Application number: 2023/93076	
What is the application for?:	External alterations to former bank building to form restaurant and takeaway, in
Address of the site or building:	former Lloyds Bank, 22, Carr Lane, Slaithwaite, Huddersfield, HD7 5AN
Postcode:	HD7 5UT

Type of comment: An objection	
Do you wish your comments to be published on the website anonymously?	Yes

Proposed North East Elevation - 1:50

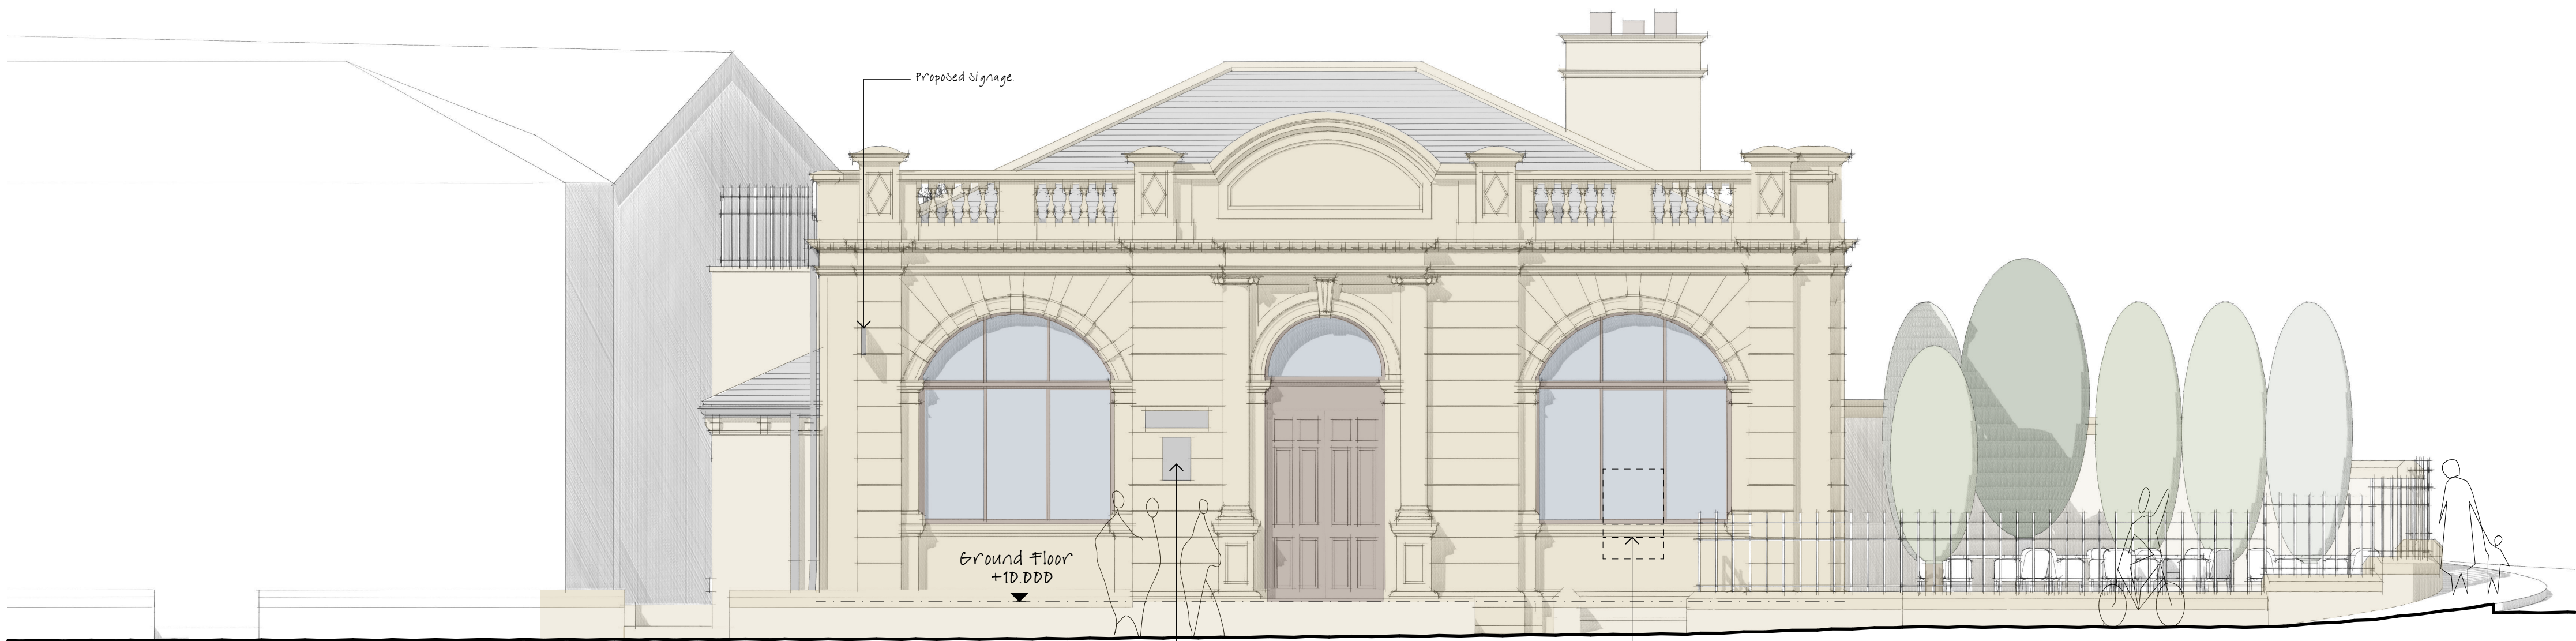
Excessive noise and smells and smoke from extractor fans that will not be limited to opening hours only and that will permeate directly into our property and prevent us opening windows due to the smell as the kitchen is to be situated backing on to Lewisham Road. The extraction fan will be directly level with the ground floor of our property, less than 10m from our boundary and the extraction system will be visible from the upstairs of our property. Having observed the amount of smoke and odour generated by the existing Rumpus in the village and the proposed siting of the extraction fan, Lewisham Road will be permanently in a fog of smoke.

Proposed outside seating area and the raising of an external wall and black railing will have an adverse effect on the character of the building and significantly effect the character of the area that backs on to Lewisham Road, along with the proposed extension that will alter the neoclassical style of the building, in what is a conservation area in Slaithwaite.

Proposed Ground Floor Plan - 1:50

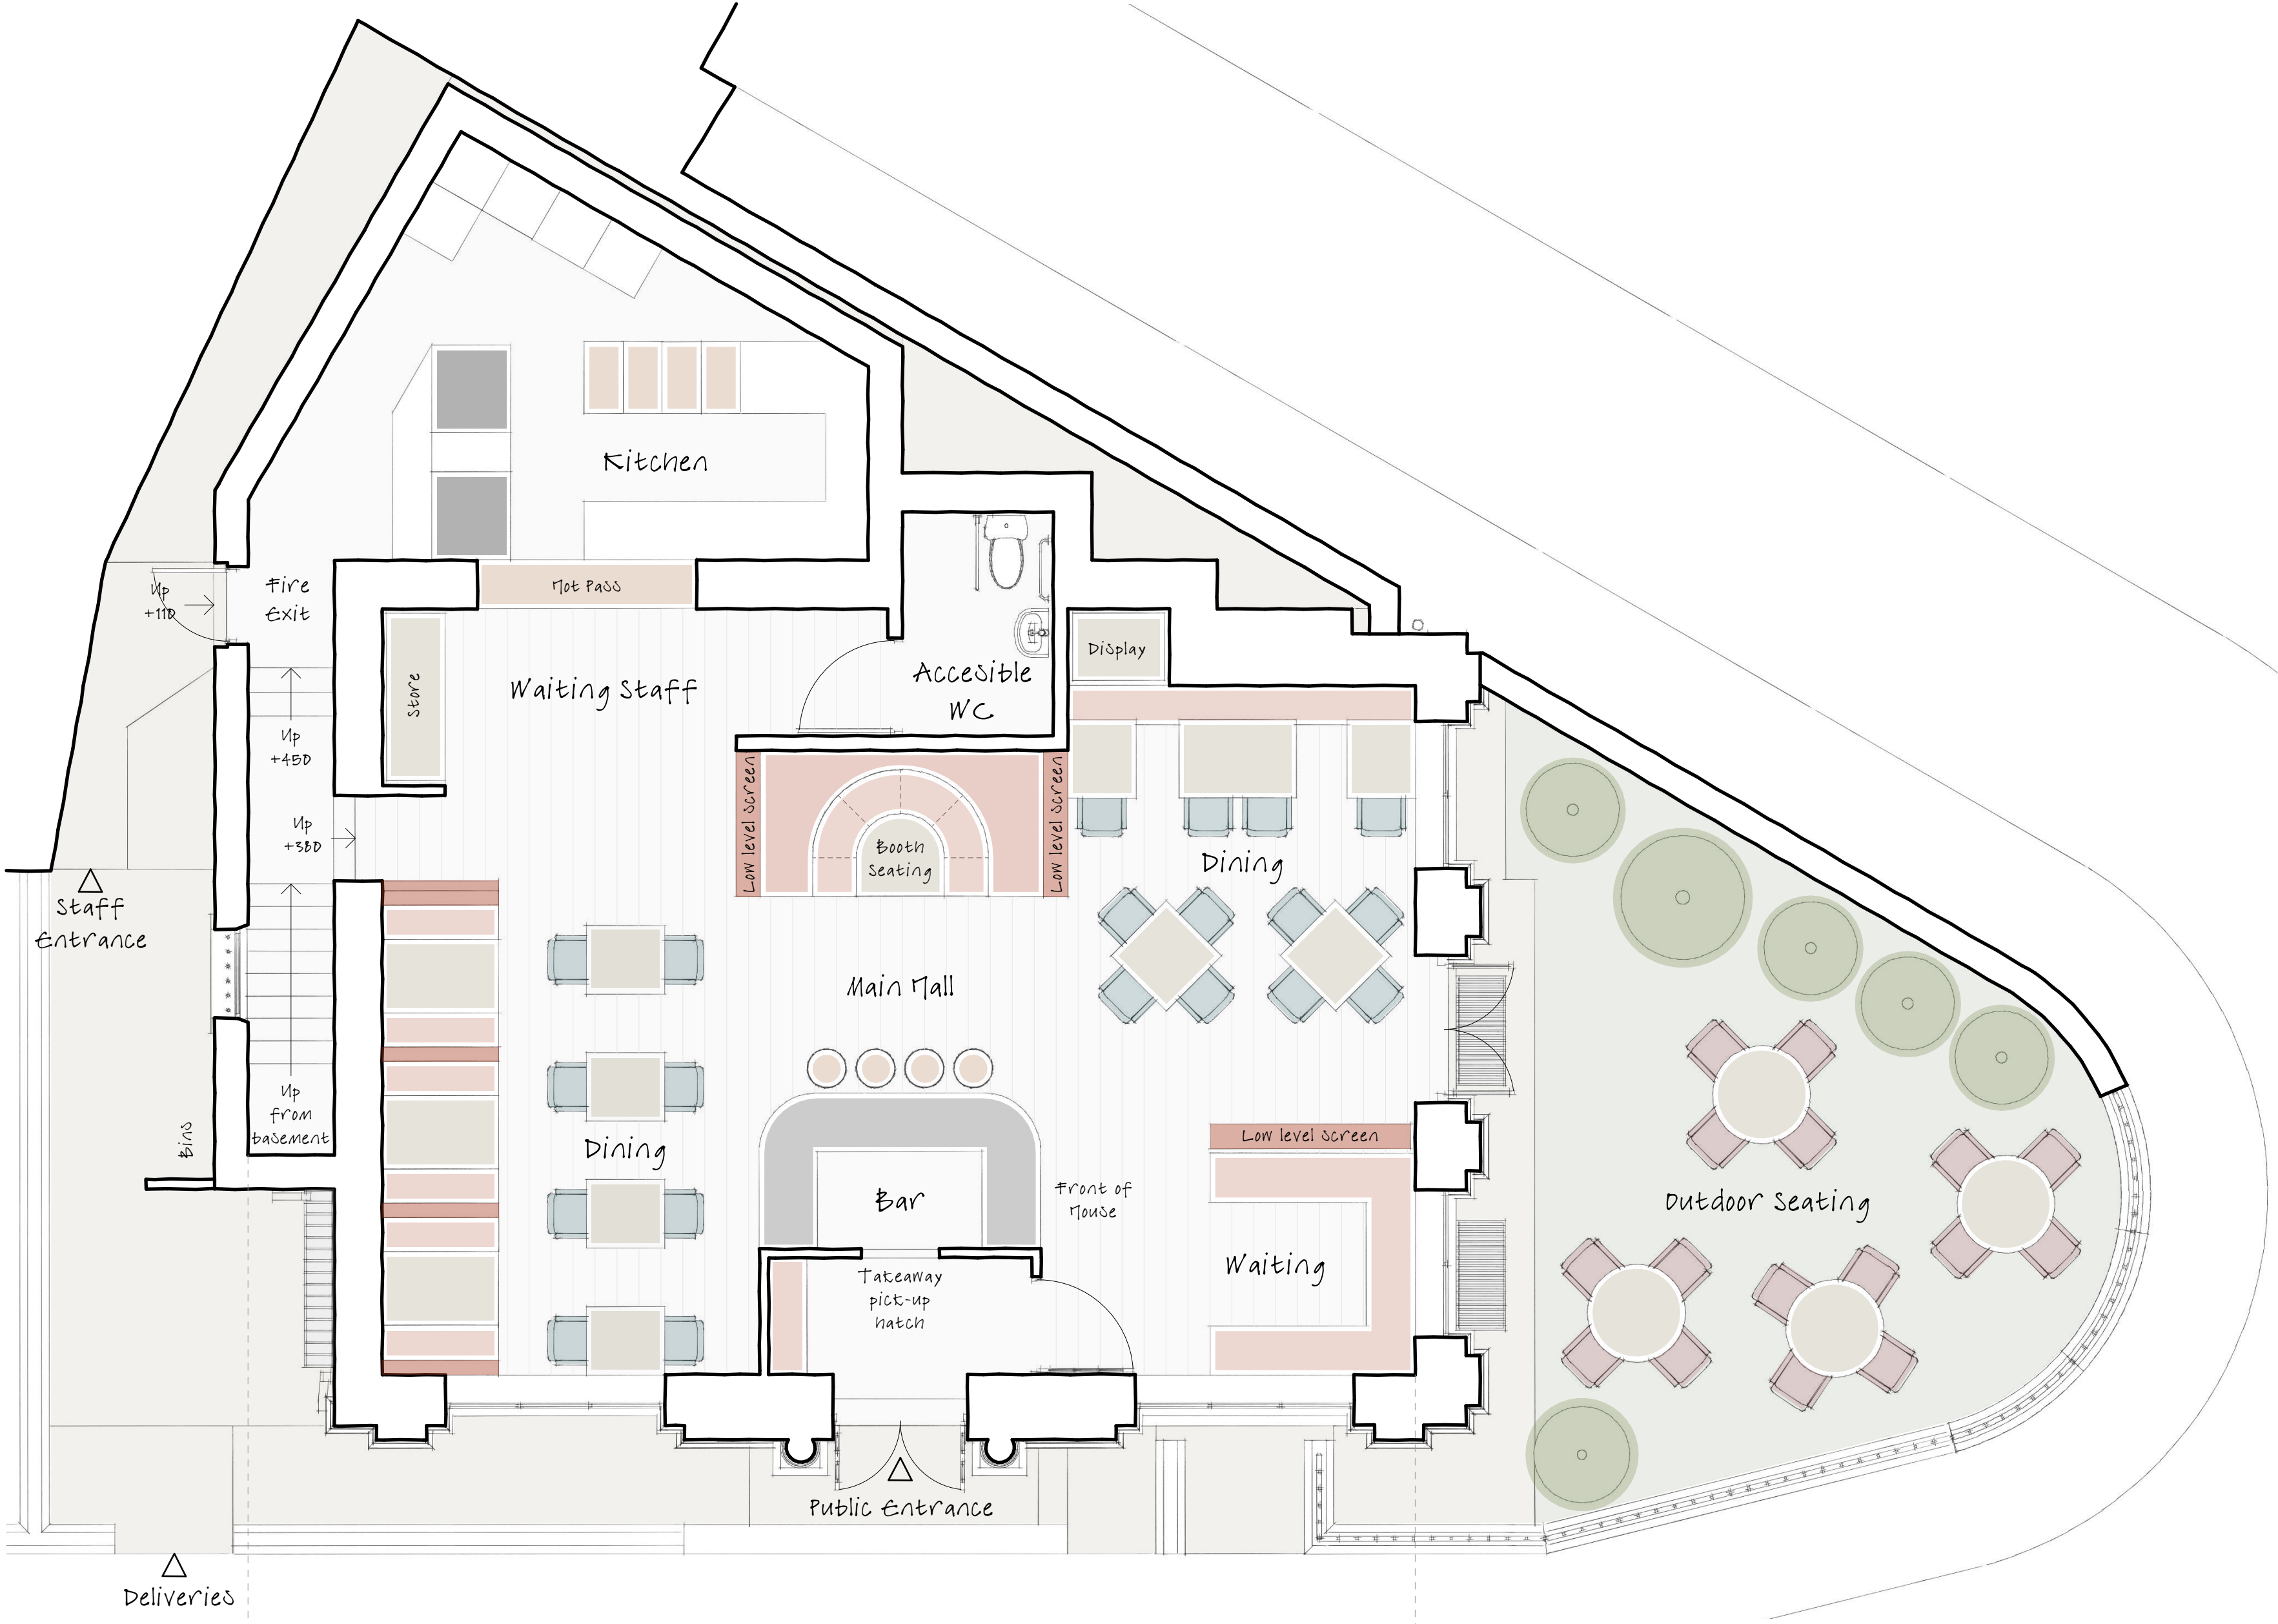
The application states there are no trees or hedges on the proposed site – there is a green area situated on the corner of the plot that includes a mature holly tree and other bushes and hedges that are a haven for birds and other wildlife and would be removed to accommodate the outside seating.

The outside seating area will also contribute to excessive noise being heard until late evening in our property. Highly likely that we will see an increase in rubbish not being disposed of by patrons.

The bins at the current restaurant are roadside and overflowing, I do not believe the area allocated for bin storage in this is big enough and rubbish is likely to blow onto Carr lane and the adjacent property that is Cobweb antiques. In the summer this could become very smelly and attract vermin whilst spoiling Cobwebs courtyard area.
